WEST SUSSEX COUNTY COUNCIL CONSULTATION

TO:	Arun District Council FAO: Mr S Davis
FROM:	Highways, WSCC
DATE:	03/08/2018
LOCATION:	Rear of 94-100, Hook Lane, Rose Green, Bognor Regis, PO22 8AT
SUBJECT:	BR/139/18/OUT Outline application with some matters reserved for the demolition of 1 No. existing dwelling to form access for 6 No. residential dwellings.
DATE OF SITE VISIT:	
RECOMMENDATION:	☒ Advice ☐ Objection ☐ Modification ☐ No Objection ☐ More Information ☐ Refusal
S106 CONTRIBUTION TOTAL:	£N/A

drawing
FEASIBILITY SITE PLAN

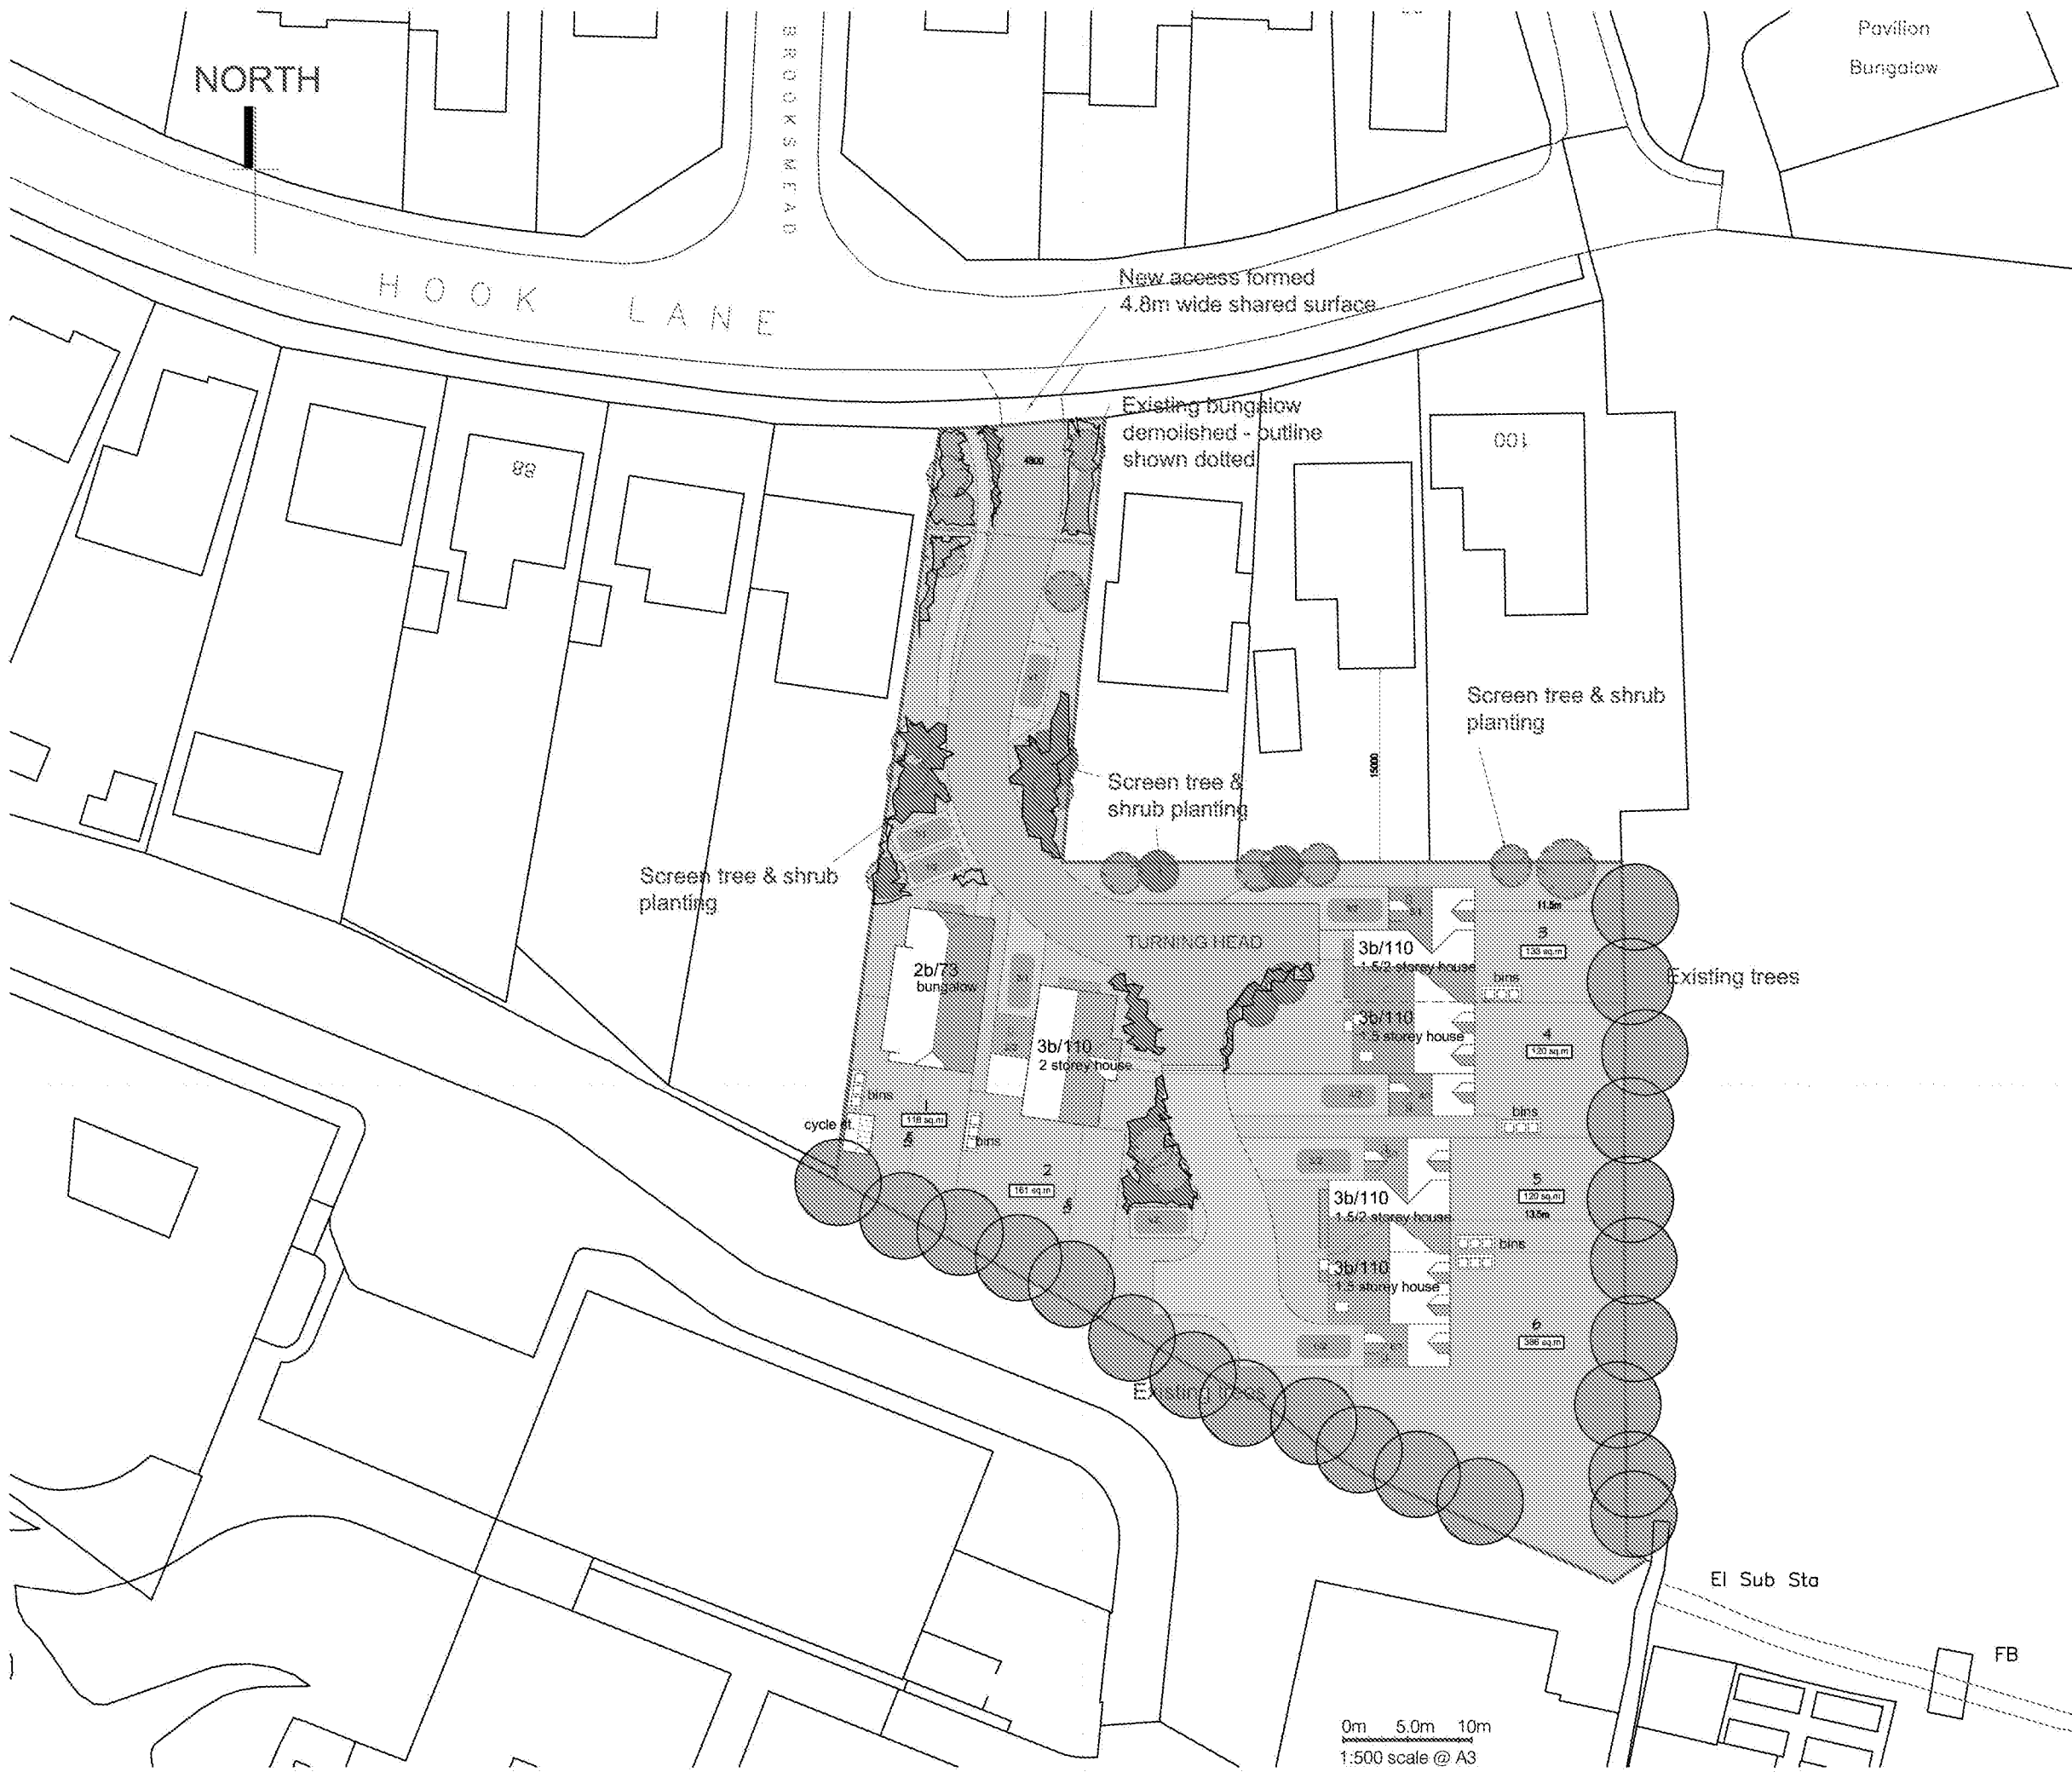
The applicant has stated within the application form their intention not to have this new road adopted by WSCC. The access takes the form of a 4.8m wide shared surface arrangement which is considered suitable to allow for two vehicles to pass one another

Visibility from the point of access onto the highway can be achieved wholly within the highway boundary in this location due to the presence of a wide verge and footway fronting the property. 2.4 x 43m can be achieved in both directions in line with Manual for Streets guidance for a road of this speed.

Due to the proximity to Chichester University, the associated sports fields and allotments, the LHA considers that the applicant should provide pedestrian visibility splays at the point of access onto Hook Lane. There should be splays between a driver's viewpoint 2m back into the access and a distance measured along the back of the footway for 2m on each side of the viewpoint. See the diagram below. These splays should be kept free of obstructions and planting exceeding 0.6m high.

Parking must be accommodated for within the site and meet the requirements as set out within the WSCC Parking Demand Calculator. Parking spaces must measure 2.4 x 4.8m each, garage spaces 3m x 6m for a single space and parallel parking bays 2m x 6m. Secure and covered cycle parking must be provided for each dwelling. The parking layout must accommodate for vehicles to turn and egress the site in a forwards gear.

Means of refuse collection is to be outlined within any subsequent application, turning for the refuse vehicles entering and exiting the site or a communal refuse area near the access point are to be provided. It should also be demonstrated that a Fire Engine would have the ability to turn within the site to egress in a forwards gear.

No part of the development shall be first occupied until pedestrian visibility splays of 2 metres by 2 metres have been provided either side of the proposed site vehicular access onto Hook Lane in accordance with plans and details submitted to and approved in writing by the Local Planning Authority. These visibility splays shall thereafter be kept free of all
